From: Giles Cheetham
Sent: 13 November 2019 13:03
To: Adam Walker
Cc: Jon Evans; Emma Mills; Sharon Huddleston; DCAdmin
Subject: RE: 2019/92940 161 dwellings inc. 50 bed extra care facility at land west of, Ashbrow Infant and Nursery School, Ashbrow Road, Ashbrow, Huddersfield

[2019/92940 : on the topic of the PROW objection](#)

Public Right of Way HDU/381/20

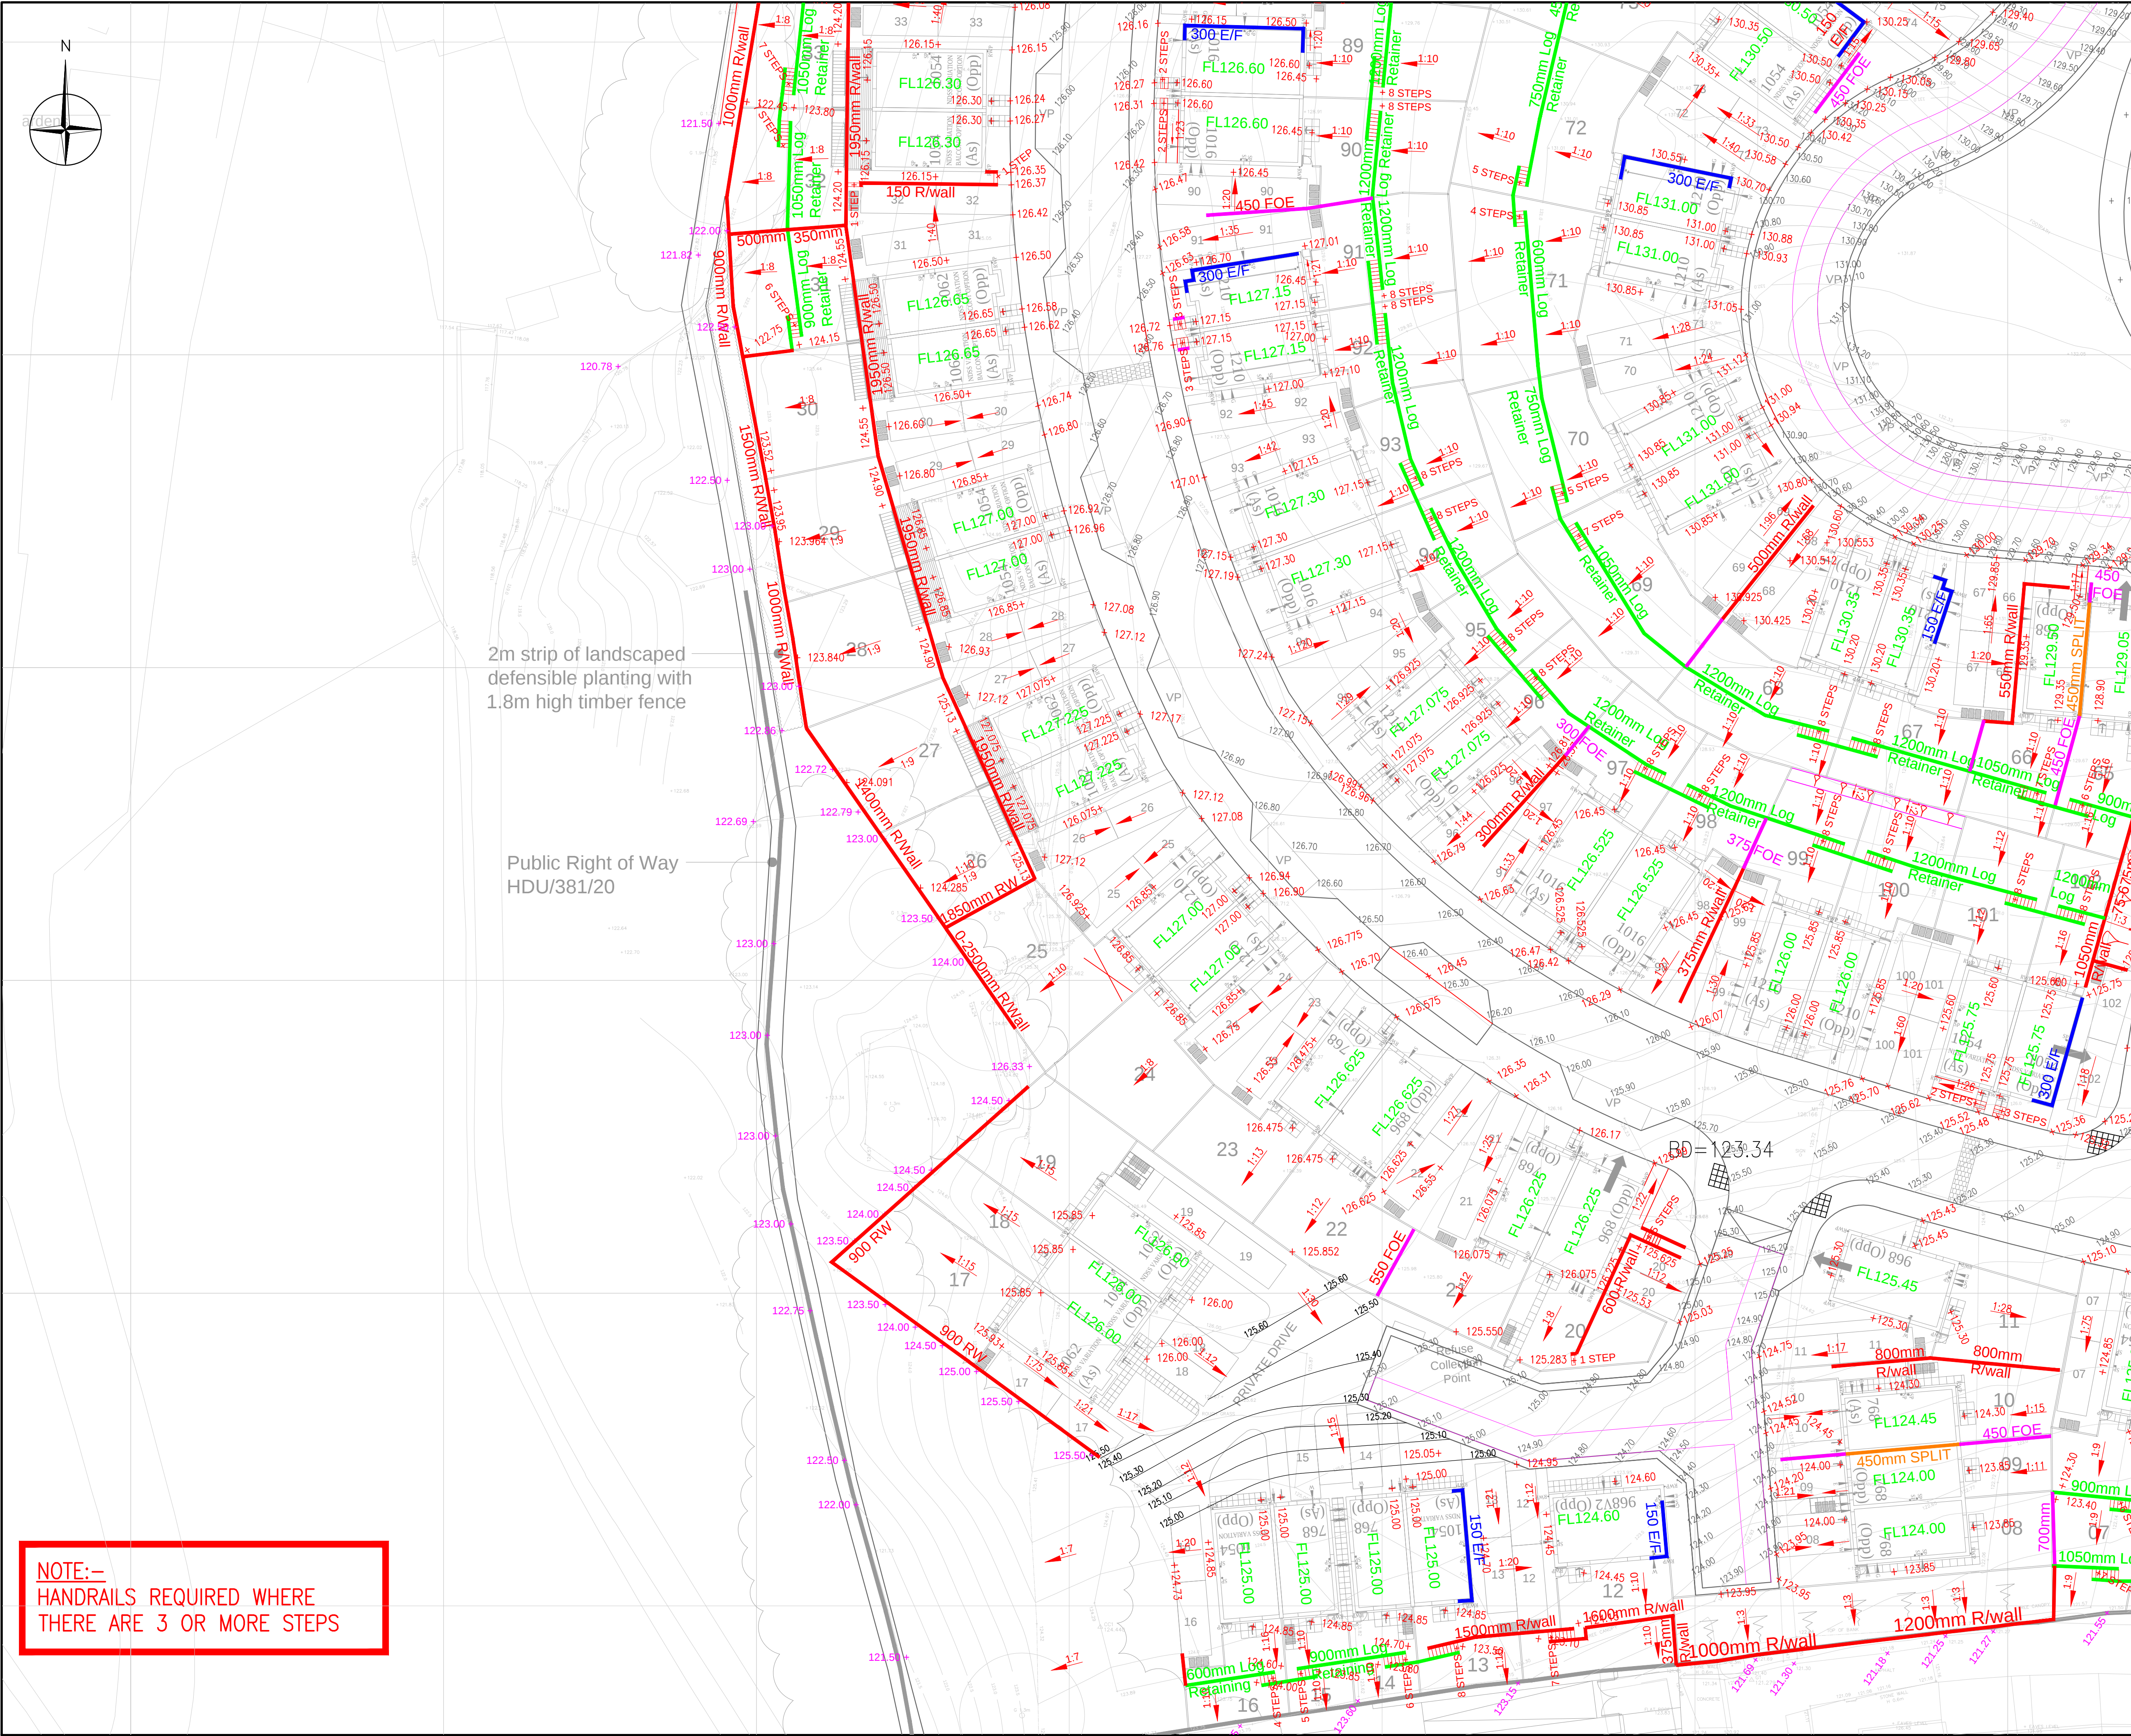
- To address objection, a condition should be added to any consent regarding a scheme for the design, agreement, provision and retention of a public path through route. This should have appropriate trigger(s). Submissions, including drawings, should identify what is intended to be done.
- The path link alignment should be re-designed to avoid the water tank footprint.

There are two submitted 'retaining wall next to the PROW' drawings. Once agreed by highways structures, these should be specifically conditioned regarding their provision and retention. There are insufficient submissions for the path improvement works (e.g. what material is the herringbone pattern representing on section C-C on drawing 272/134/1004 Rev A.) Similar on section A-A on drawing 272/134/1003 Rev A, and with both drawings also not identifying the feature retaining the PROW, while detailing the make-up of the 'garden retaining' structure. Submitted surface treatment plan drawing does not include definitive footpath Hud/382 improvement works.

- So, additionally, to address objection, a condition should be added to any consent regarding a scheme for the design, agreement, provision and retention of improvement works to the existing definitive public footpath Huddersfield 382. This should have appropriate trigger(s). Submissions, including drawings, should identify what is intended to be done.
